WEST SUSSEX COUNTY COUNCIL CONSULTATION

TO:	Arun District Council FAO: Simon Davis
FROM:	Stephen Gee, Highways, WSCC
DATE:	24/01/19
LOCATION:	10 Acre Field North of, Grevatts Lane, Yapton
SUBJECT:	Y/103/18/PL Single Chapel Crematorium with car parking, landscape works, surface water drainage features & associated highway improvements. This application is a Departure from the Development Plan.
DATE OF SITE VISIT:	15/01/19
RECOMMENDATION:	☐ Advice ☒ Objection ☐ Modification ☐ No Objection ☒ More Information ☐ Refusal
S106 CONTRIBUTION TOTAL:	£ See below for breakdown.

PBA drawing 128.001.007 Rev D

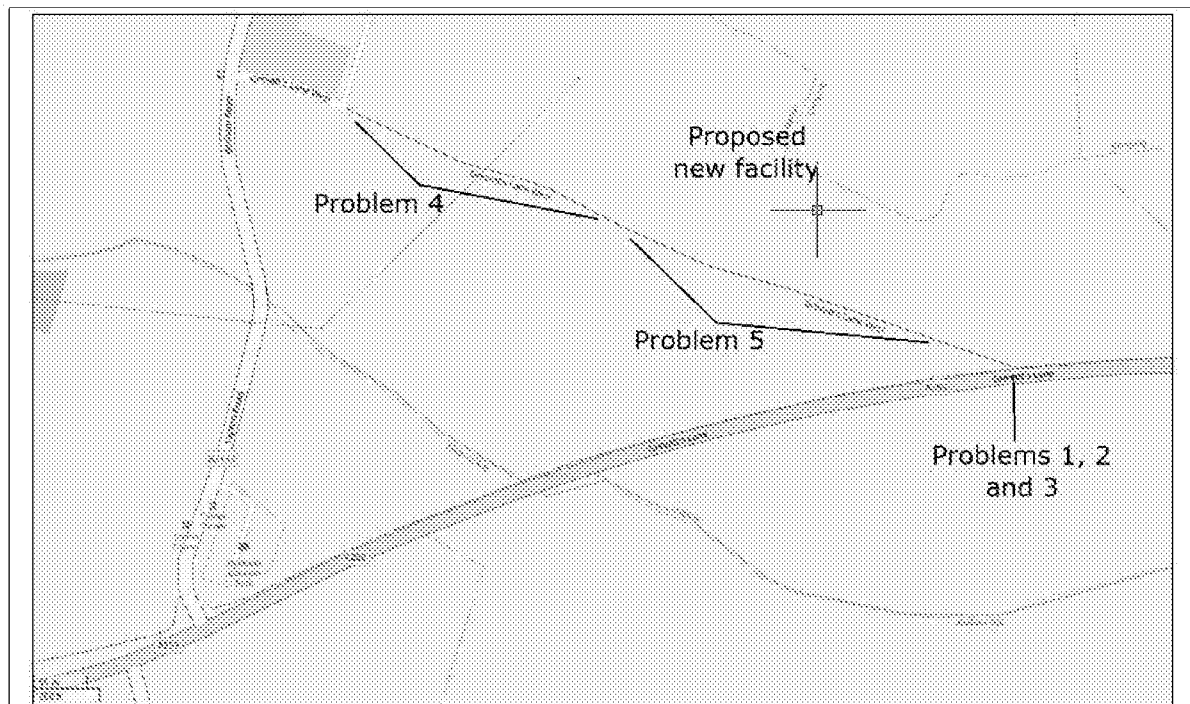
The site would be accessed by priority junction 300m to the east of the junction of the A259 and Grevatts Lane West. At the entrance to the site a build out to the western side of the access is proposed to encourage vehicles to turn right in and left out of the access. The existing carriageway would be widened by 1.8m to form a width of 4.8m to the east of the buildout the carriageway will remain at 3m to discourage vehicles travelling to Bilsham Road.

It is noted on drawing ref 128.001.007 that further measures could be introduced to reduce any potential for vehicles turning right out of the site including no right turn signage, further build out into the carriageway and a more acute angle of entry.
